From: [Bill Iverson](#)
To: [Jeremiah Cromie](#)
Subject: RE: KC Flood Control (SE-22-00053)
Date: Friday, June 17, 2022 12:06:16 PM

Subject: KC Flood Control (SE-22-00053)

Channel & Road Profile

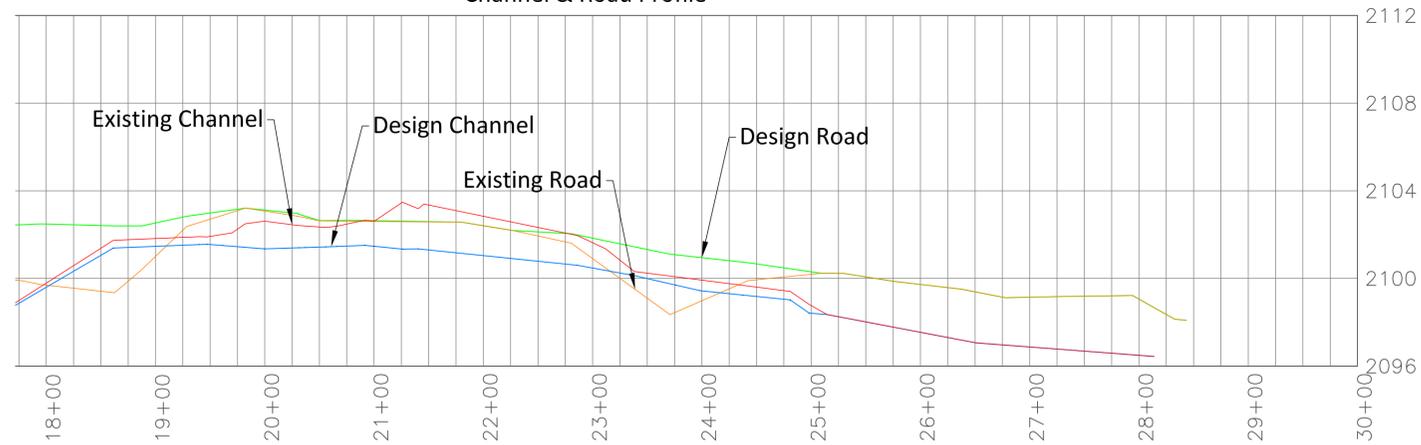
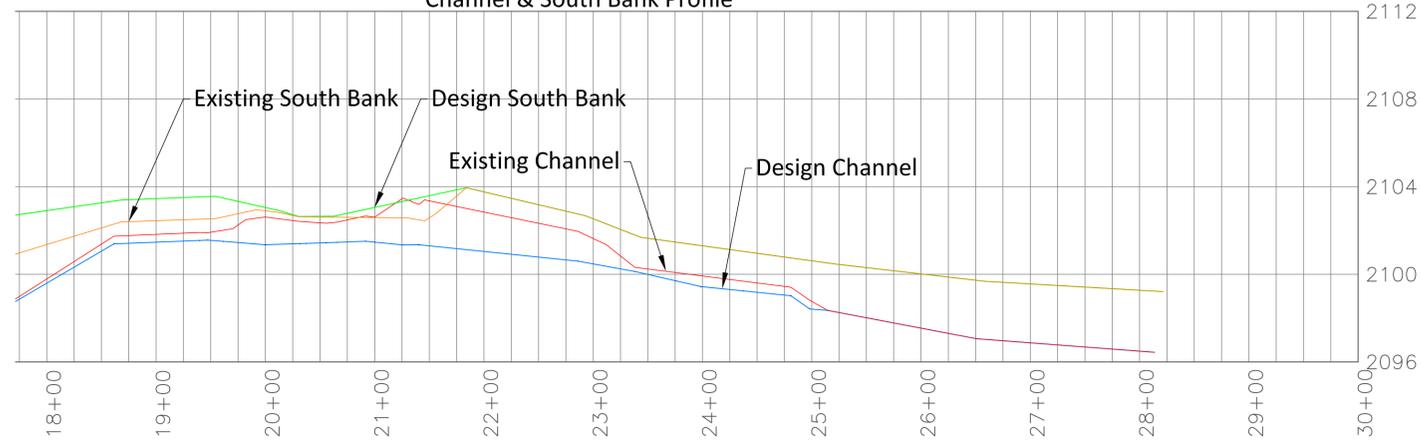
I'd like to add an update, as the "Existing Road" referenced in my earlier comments, was just resurfaced with fresh gravel, pictures attached from today. This flood water barrier is now a few inches higher, and further compacted as an unpermitted impervious surface, which worsens the problem I described in my comments.

I attach an elevation profile (KittitasCounty_DraftPlans.pdf) that we received from Kittitas County a couple years ago, after we met with County engineers at this site. My concern is that the existing (unpermitted) adjacent road is consistently at a higher elevation than the proposed drainage ditch, which will make most of the work by Kittitas County a complete waste of time. Flood waters cannot reach the proposed improvements due to the impervious surface labelled "Existing Road" on attached document.

I request details of the County plan, showing how flood waters can ever even reach the proposed improvements. Most likely that would require installation of culverts under the "Existing Road" which crosses State Park property.
